From: Russell McCourty [REDACTED]
Sent: 25 July 2017 12:22
To: Mark Jones
Cc: John Hinds
Subject: A/87/17/HH & A/88/17/L

Following comments from Ian Wightman, we have amended the main elevation as per the attached.

PROPOSED FLOOR PLANS 1:50

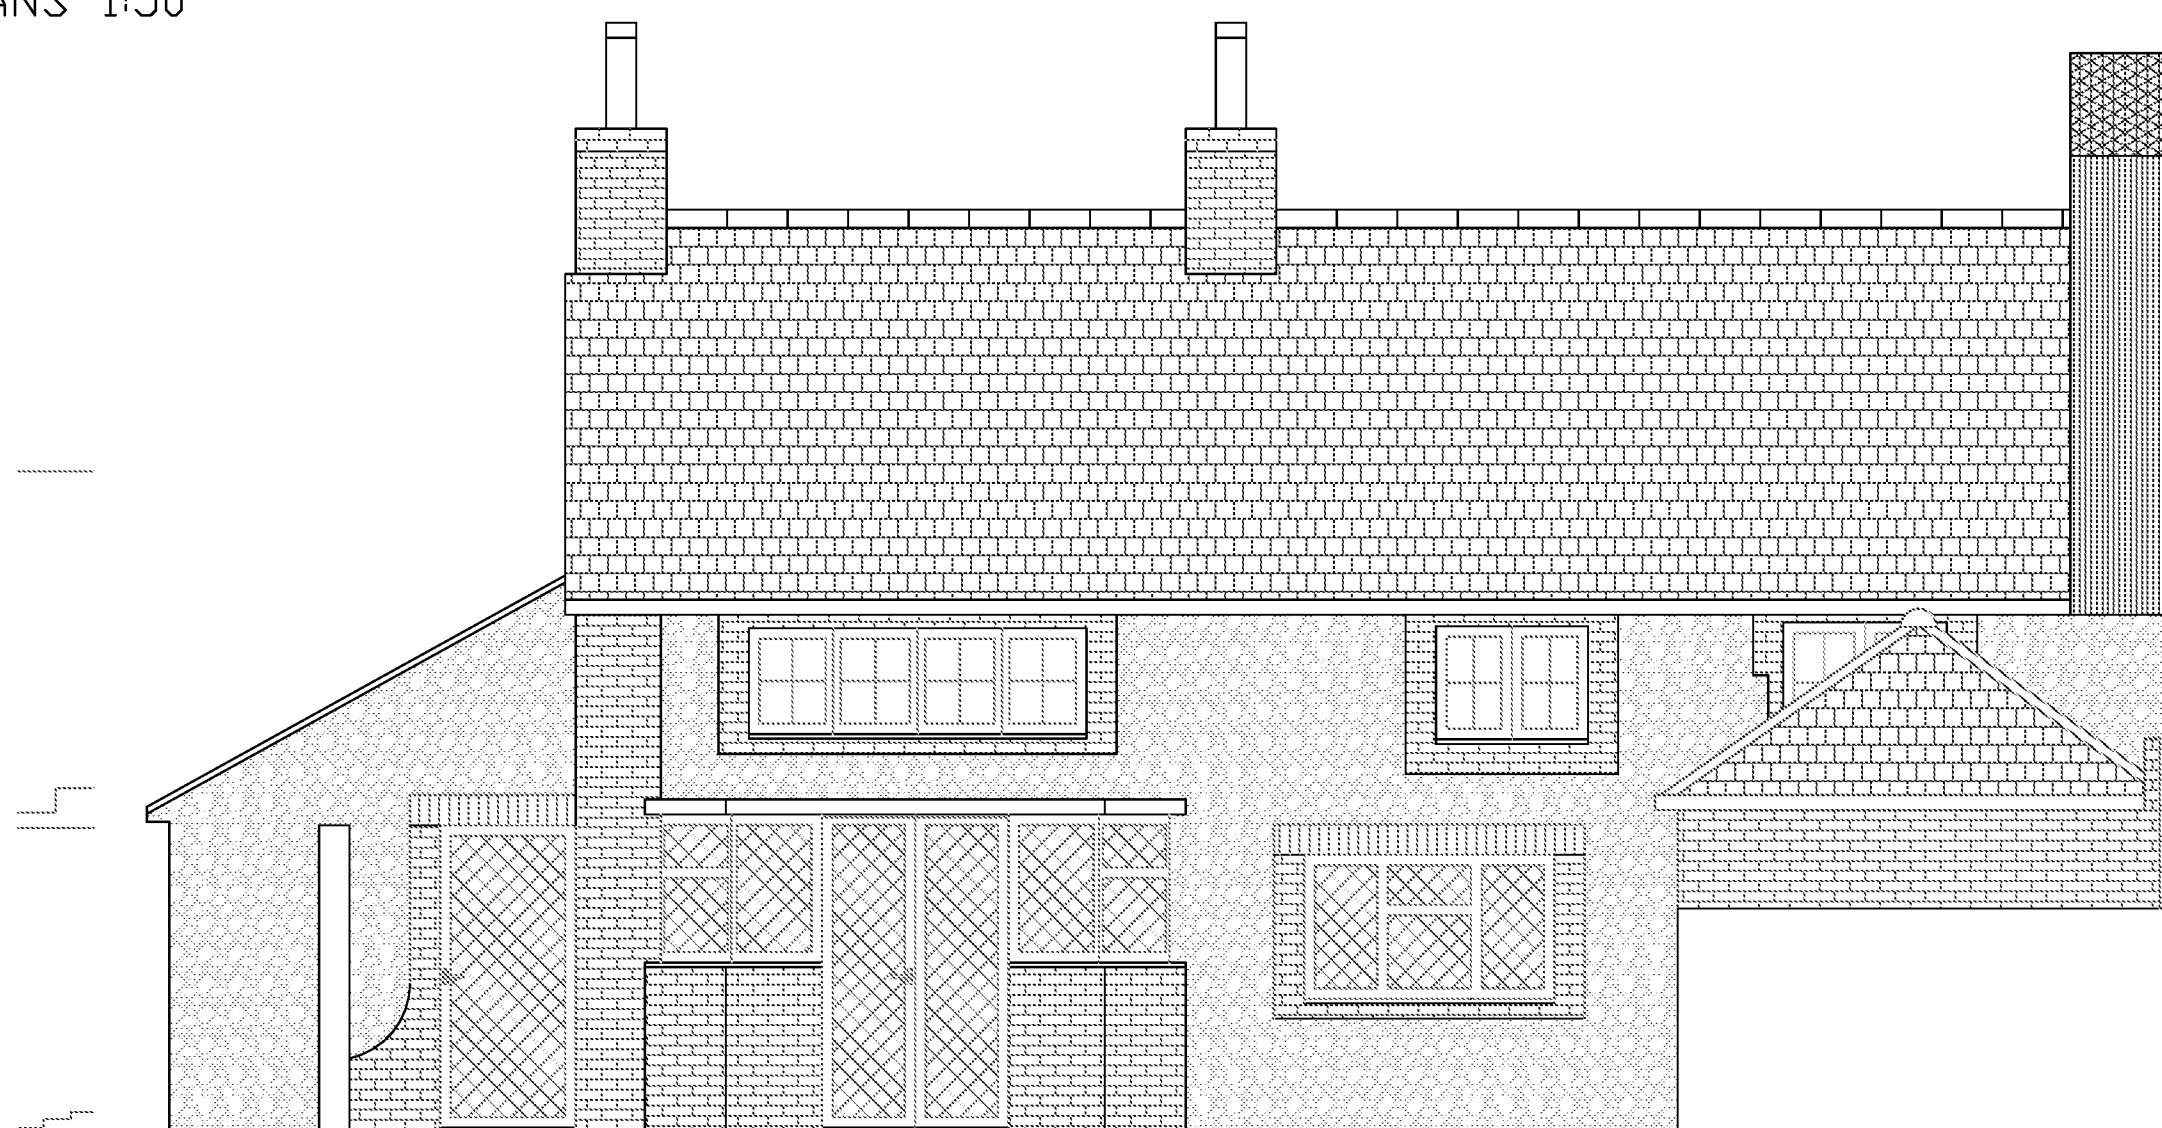
The main wall construction of the extension will be 215mm solid brick in English Bond pattern, tanked and internally insulated to bring it up to today's UK Building Regulations standard in accordance with Part L. This will make the external wall thickness approximately 290mm from outside of brick to inside of plaster.

Proposed windows and doors are to be hardwood, painted white and fitted with slim double-glazing (10-12mm). Window style to be in small panes as per the elevations (to match the existing main property).
